ENTECH
ENGINEERING, INC.

**SOILS AND GEOLOGY STUDY
RETREAT AT TIMBERRIDGE FILING NO. 4
PARCEL NO. 52220-00-023
EL PASO COUNTY, COLORADO**

December 21, 2023

**EXTENDED DETENTION BASIN DETAIL**

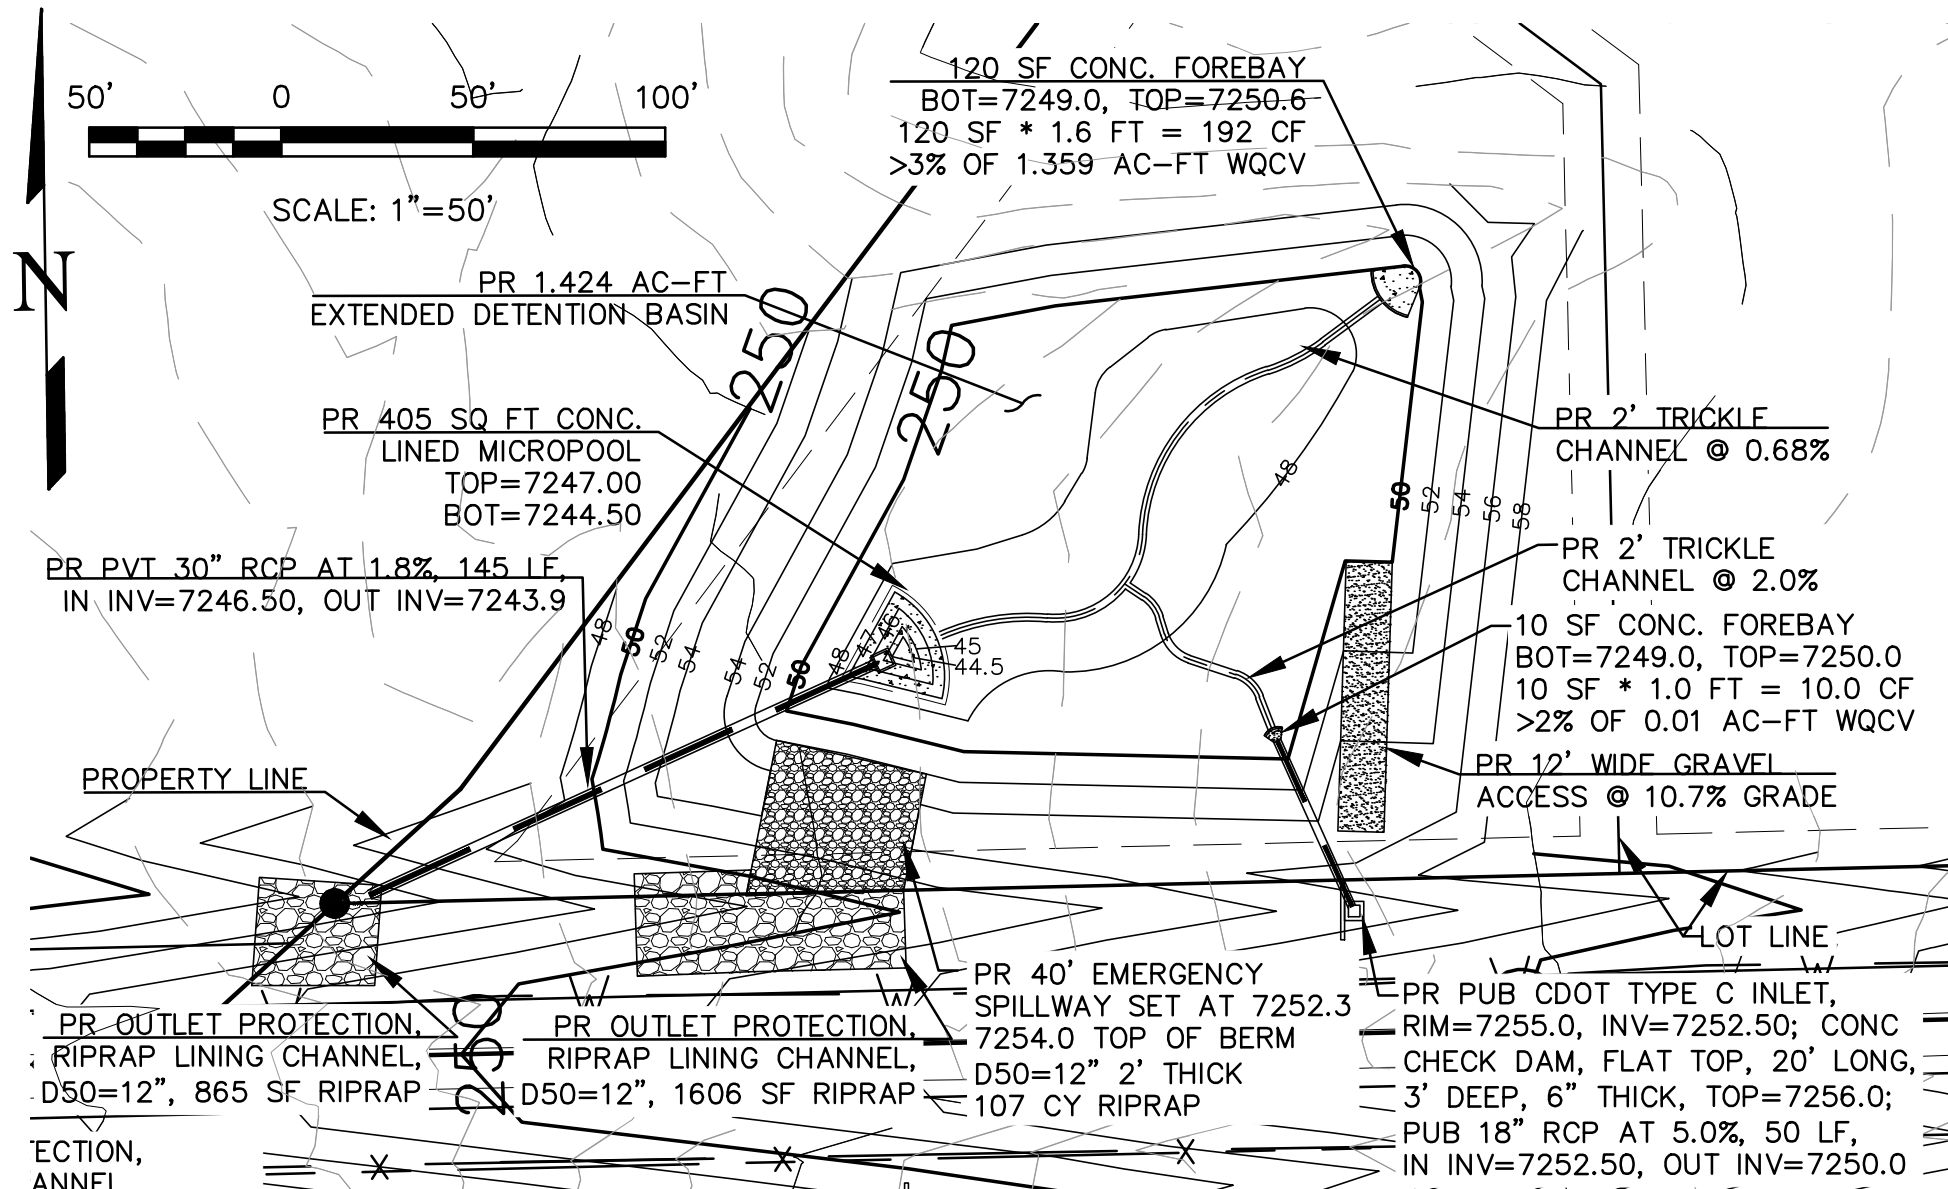
Unresolved: There is a strip of potentially seasonally shallow groundwater located along the pond embankment, how will this be mitigated? See excerpts from MHFD's DCM Volume 2 and 3 for potential concerns with groundwater in an EDB and the recommended mitigation options (like a clay or geomembrane liner). Please discuss this potential shallow groundwater in the report text. If you decide not to design for mitigation now and shallow groundwater is encountered during or after construction (or at PA/FA), proper mitigation and permitting will need to be implemented at that time. The below discussion is limited to building construction not mitigation for the proposed pond.
